From: Erin Moore
Sent: Wednesday, August 13, 2014 4:12 PM
To: Kaycee Hathaway
Subject: RE: Notice to Agencies: BL-14-00015 Leensvart

From: Kaycee Hathaway
Sent: Thursday, August 07, 2014 10:18 AM
To: Christina Wollman; Brenda Larsen; Jan Ollivier; Holly Duncan; Erin Moore; Joe Gilbert
Subject: Notice to Agencies: BL-14-00015 Leensvart

LOT LINE ADJUSTMENT

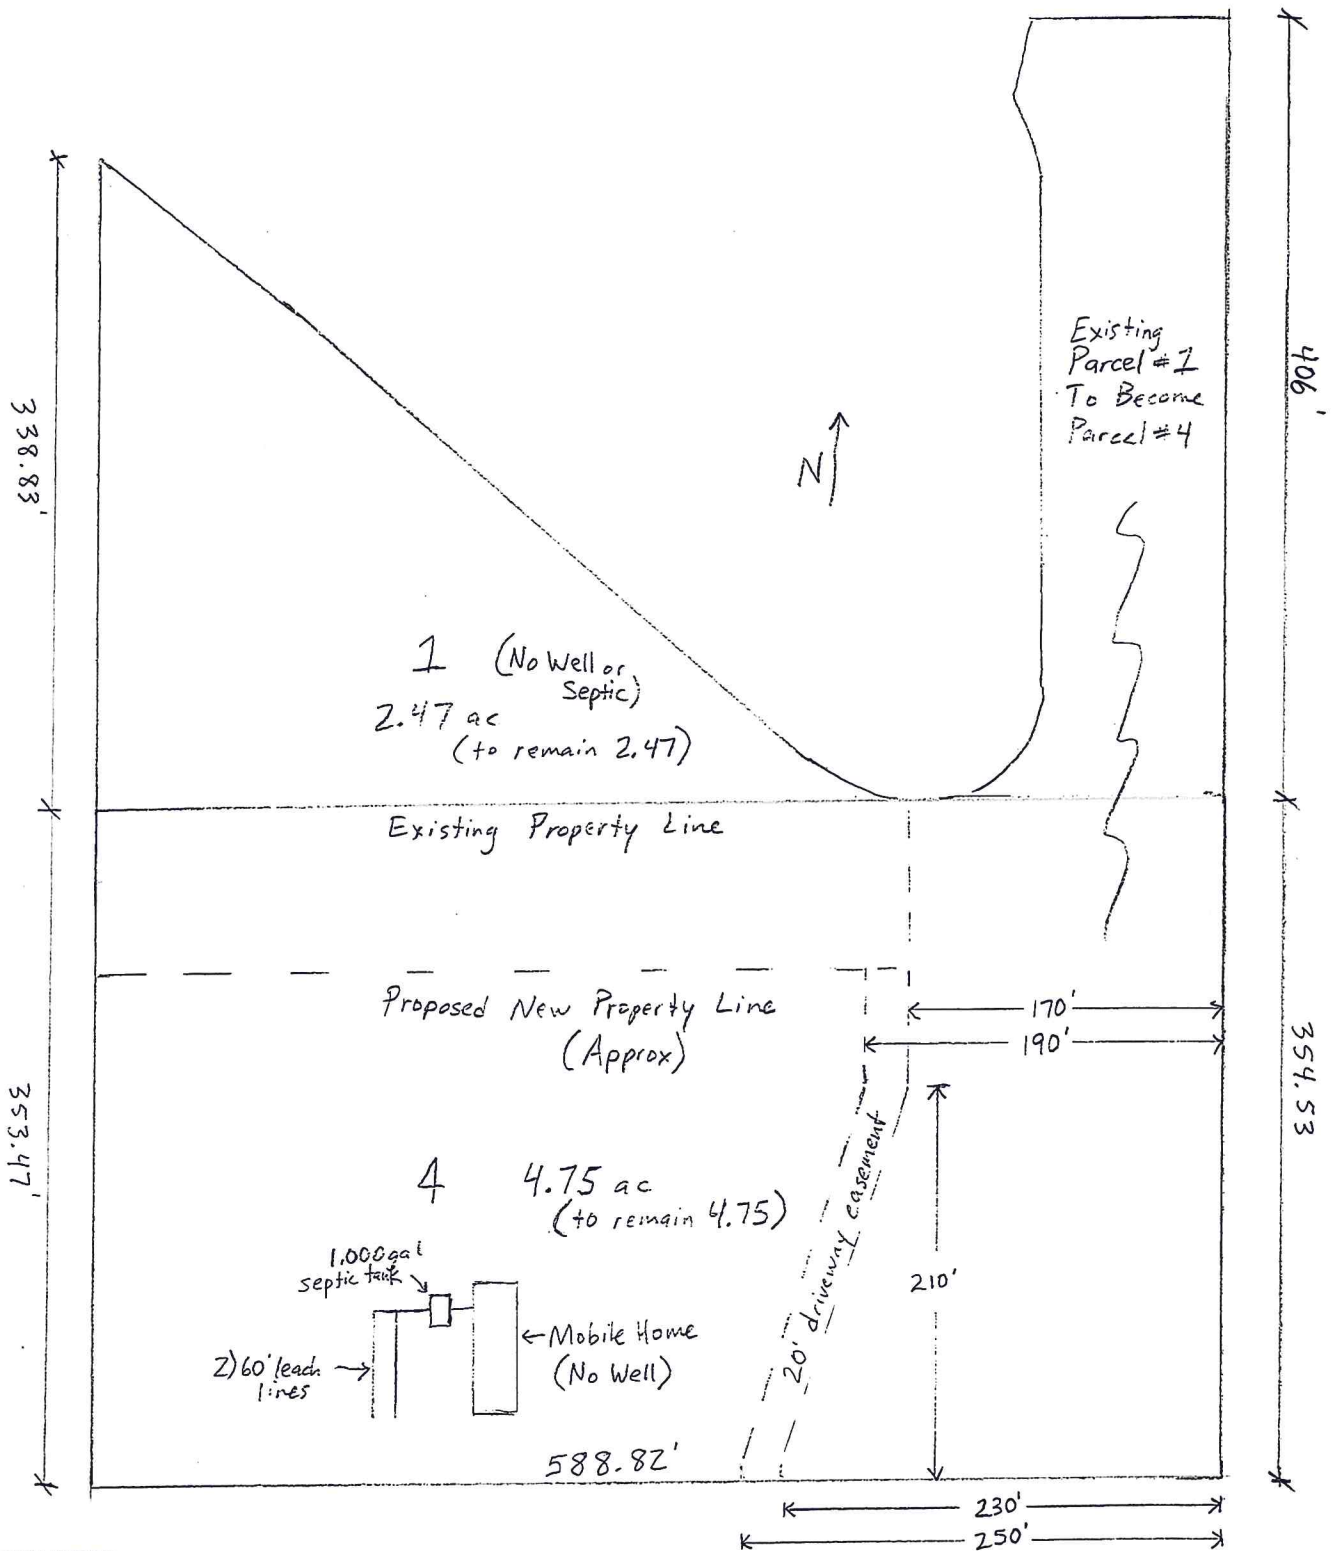
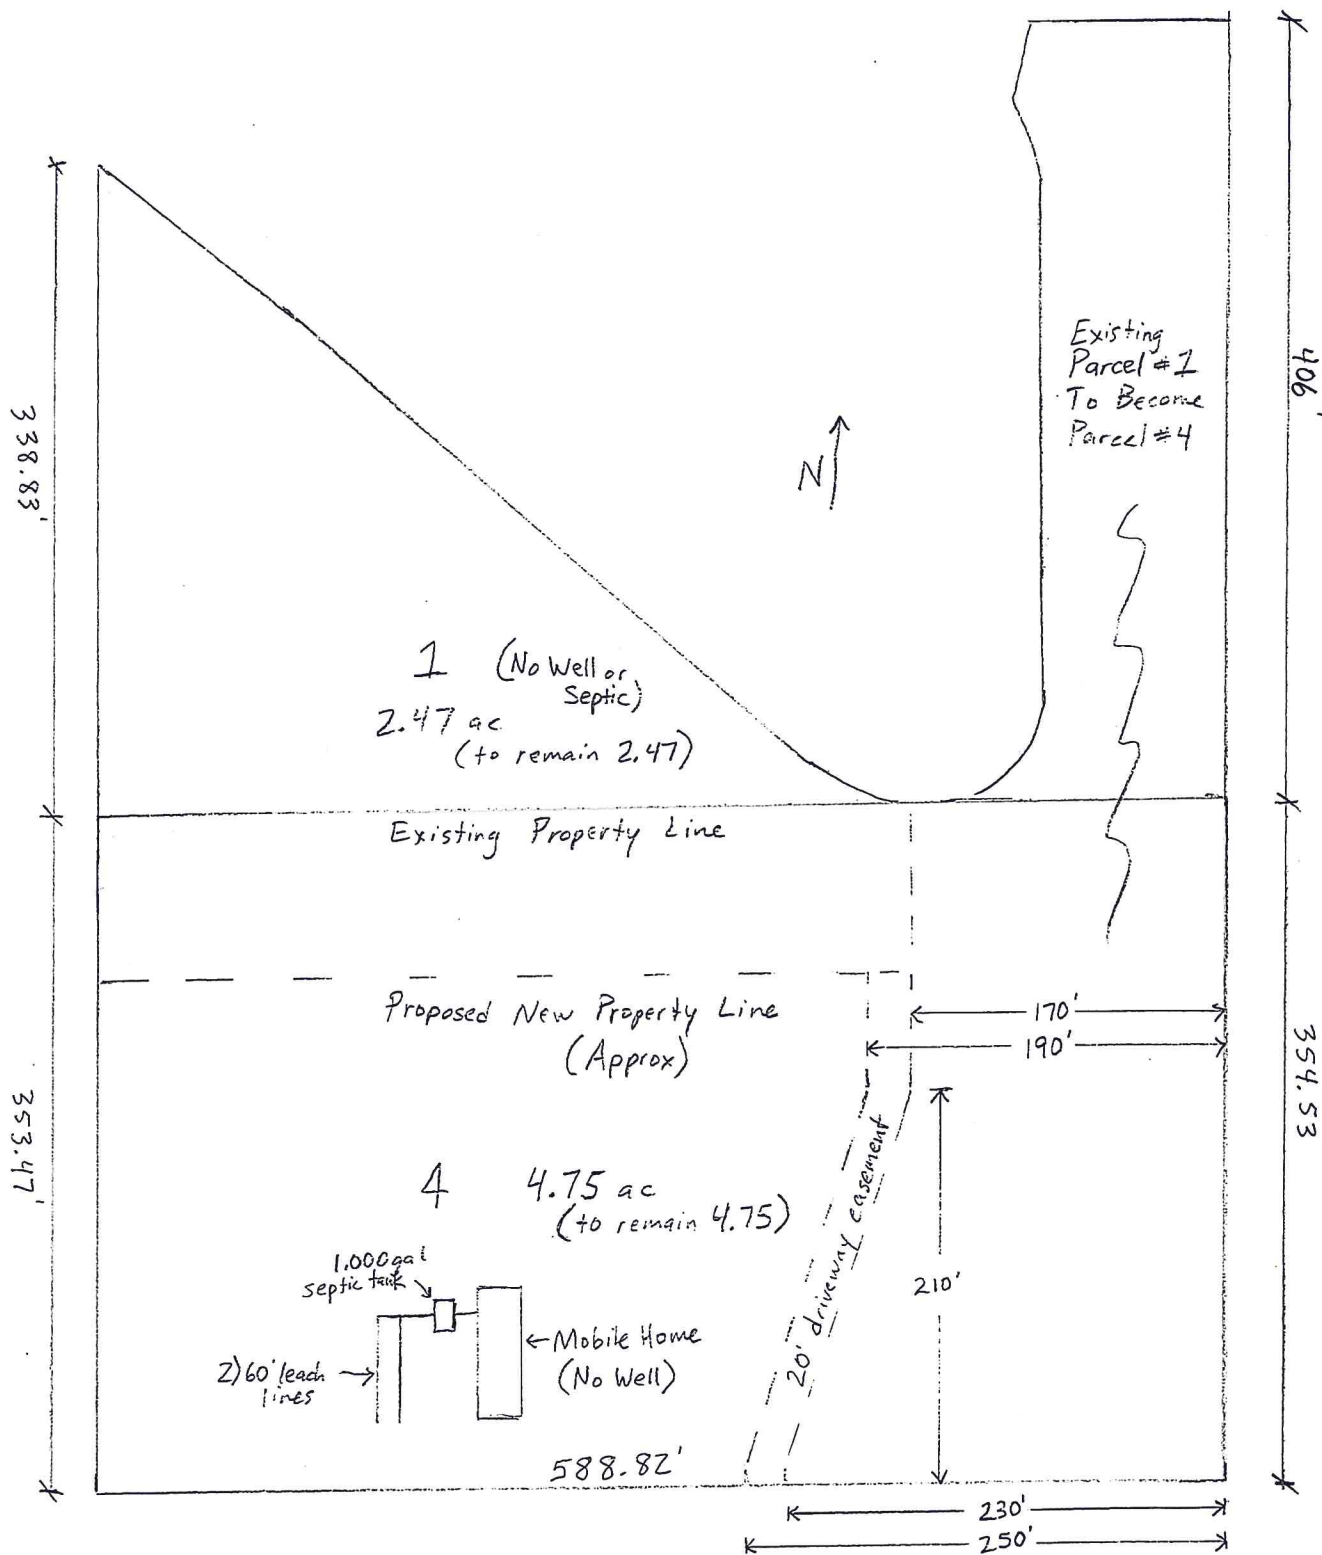
I cannot make comments until we know septic and well locations. Thank you.
